## Online Comment

**Application** H09-0244-25  
**Location** Westholme 32 West End Holbeach  
**Proposal** Conversion of existing basement to create 1 flat

PROPOSED ELEVATION
 scale 1:100

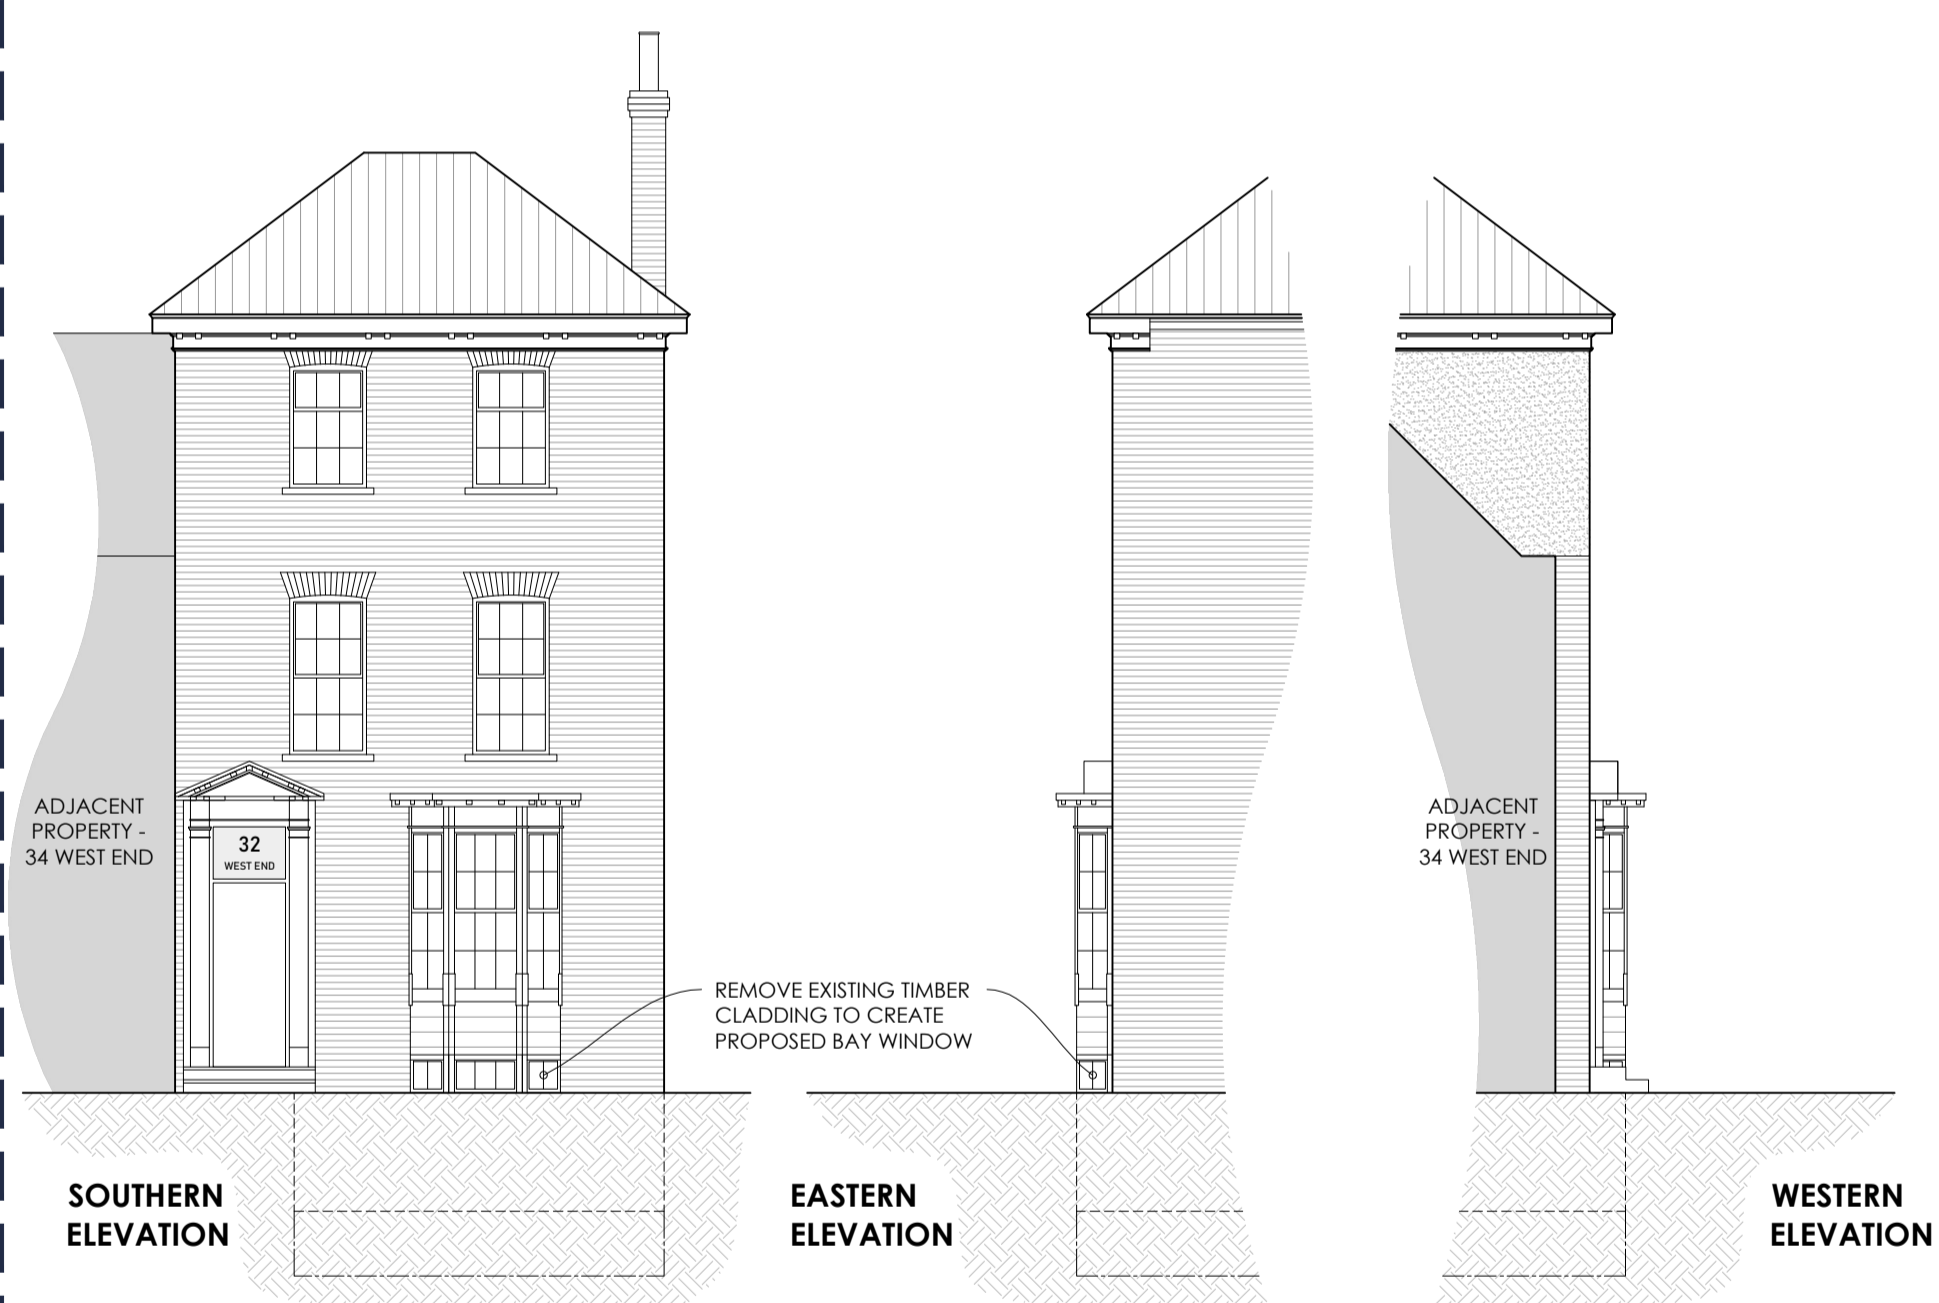
Additionally, details of the proposed windows ought to be secured by means of pre-installation condition.

PROPOSED SECTION
 scale 1:100

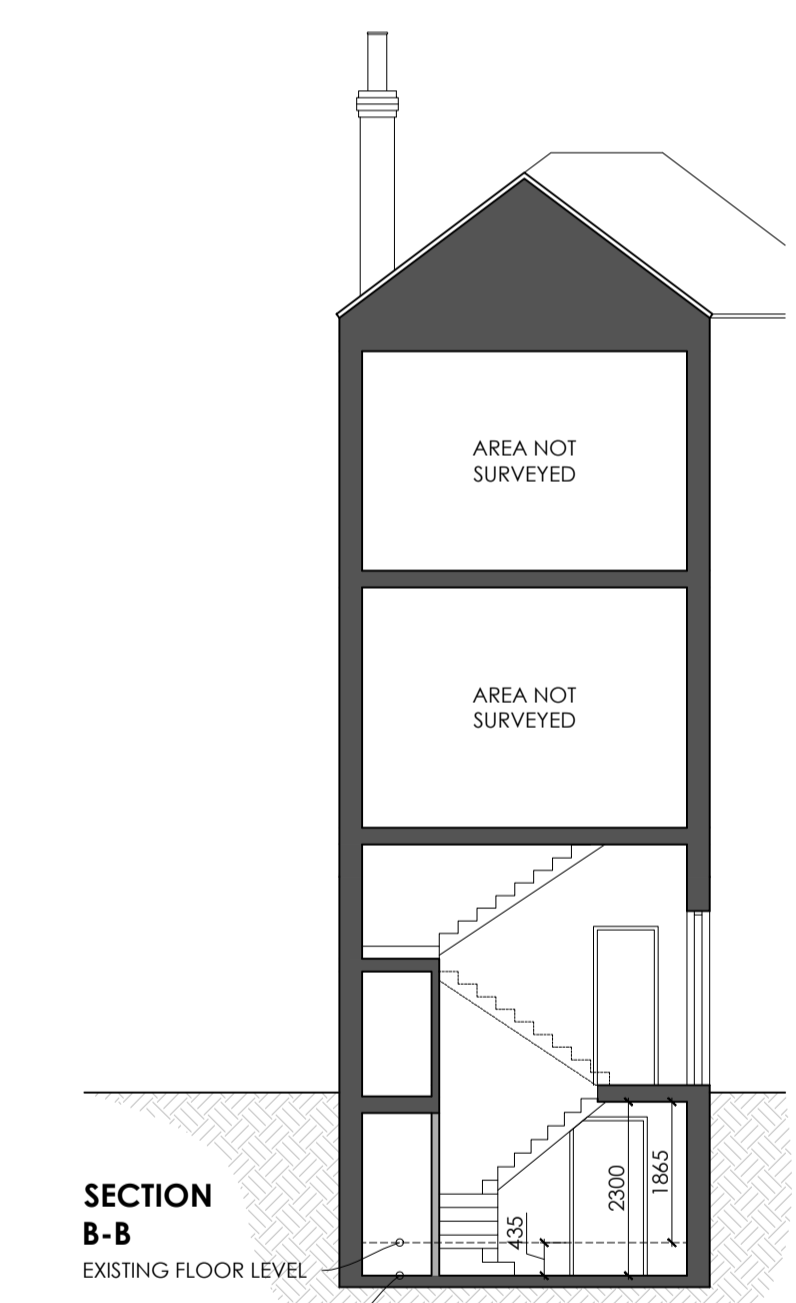
No objections. However, I echo the comments of my colleague from the LCC Historic Places team in requesting that the lowering of the basement floor is archeologically monitored.
